**EL PASO COUNTY PLANNING AND  
 COMMUNITY DEVELOPMENT  
 DEPARTMENT**

**STORMWATER MANAGEMENT PLAN CHECKLIST  
 MIDTOWN COLLECTION AT HANNAH RIDGE FILING NO. 1 (SF-19-007)**

Revised: July 2019

MIDTOWN COLLECTION AT HANNAH RIDGE
FILING NO. 1
OVERLOT GRADING AND EROSION CONTROL PLAN

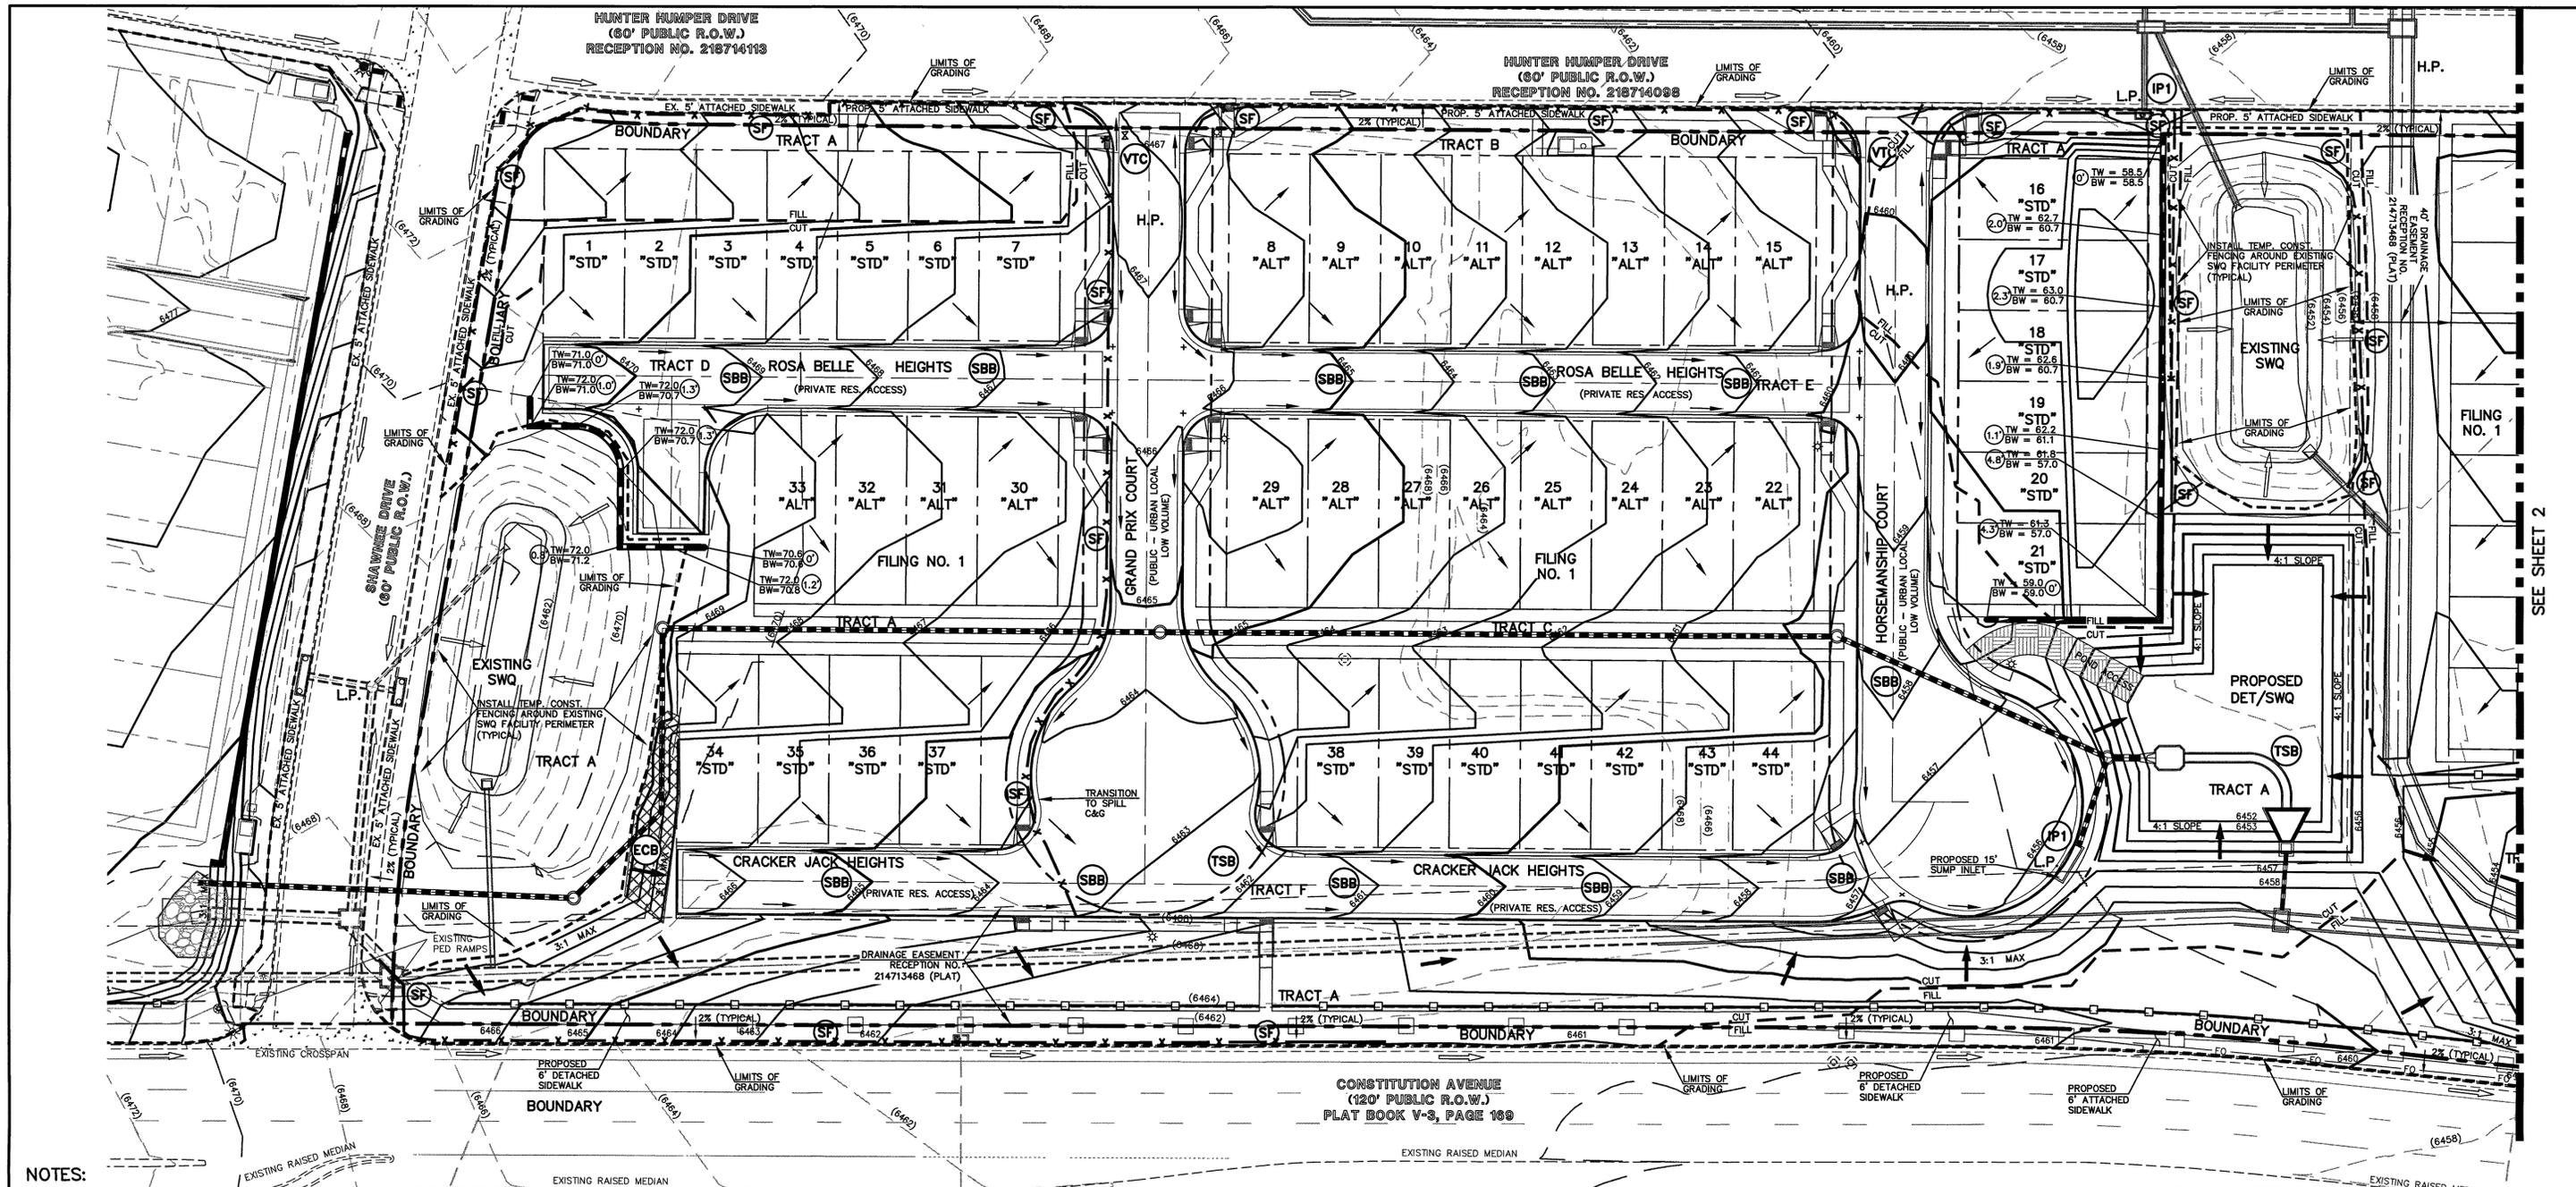
Applicant	PCD
<b>1. STORMWATER MANAGEMENT PLAN (SWMP)</b>			
1	Applicant (owner/designated operator), SWMP Preparer, Qualified Stormwater Manager, and Contractor Information. (On cover/title sheet)	X	✓
2	Table of Contents	X	✓
3	Site description and location to include: vicinity map with nearest street/crossroads description.	X	✓
4	Narrative description of construction activities proposed (e.g., may include clearing and grubbing, temporary stabilization, road grading, utility / storm installation, final grading, final stabilization, and removal of temporary control measures)	X	✓
5	Phasing plan – may require separate drawings indicating initial, interim, and final site phases for larger projects. Provide “living maps” that can be revised in the field as conditions dictate.	N/A	✓
x	Proposed sequence for major activities: Provide a construction schedule of anticipated starting and completion dates for each stage of land-disturbing activity depicting conservation measures anticipated, including the expected date on which the final stabilization will be completed. <b>Need Dates</b>	X	✗

Need Dates
